Subject: Y/24/20/PL, Fresh Acres Lighting

Subject: FW: Fresh Acres Lighting

3.2.1 Isolines representation, Horizontal Spillage (E)

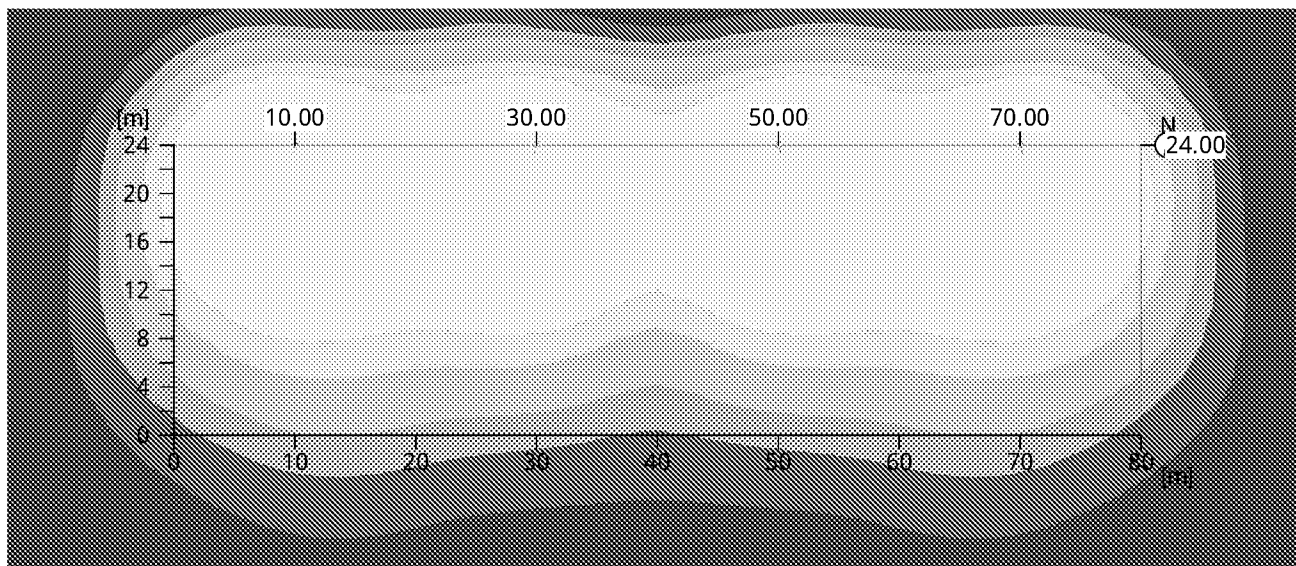
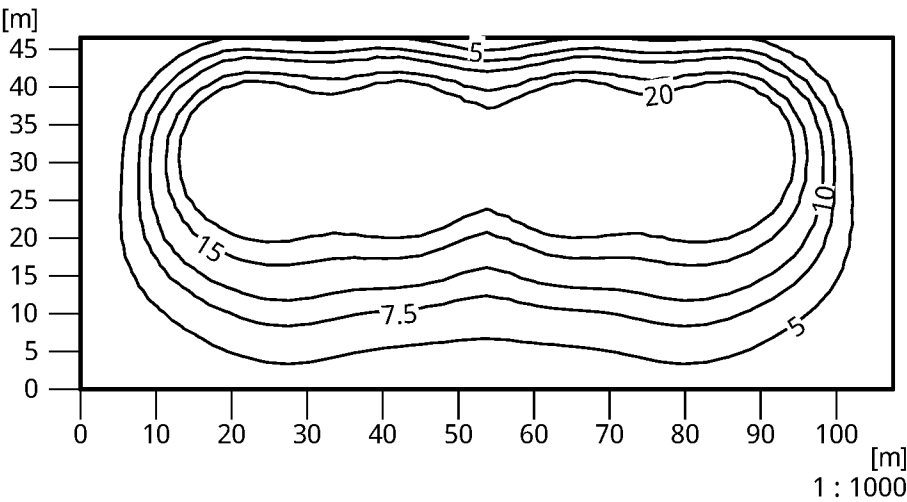
This plan shows the cctv and light points directed away from field house so coupled with the comments below from the applicant I am happy that the you don't need to include the lighting condition that I suggested. This assumes that you can hold the applicant to these locations and the details below and enforce it if necessary, particularly if there were problems at Southdown Cottage although I consider this to be far enough away and screened by the containers etc so that it is unlikely to cause a problem.

Our lighting consultant has confirmed, : 'Light intrusion into residential windows shall not exceed 10 Lux between 07:00 and 21:00 hours and 5 Lux between 21:00 and 07:00 hours, measured as Vertical Illuminance (EV) normal to glazing. The Sky Glow (Upward Light Ratio) shall not exceed 5.0%

As shown in the attached drawings the light level is no more than 5 lux beyond the perimeter of the site and the Upward light ratio is 0.01, which equates to 1%.

However, it would be useful if I could see a plan of where the proposed lighting is to be located on the site, just to be sure that there shouldn't be a problem.

The lighting will be on the poles as previously discussed, shown on the attached plan and marked CCTV.
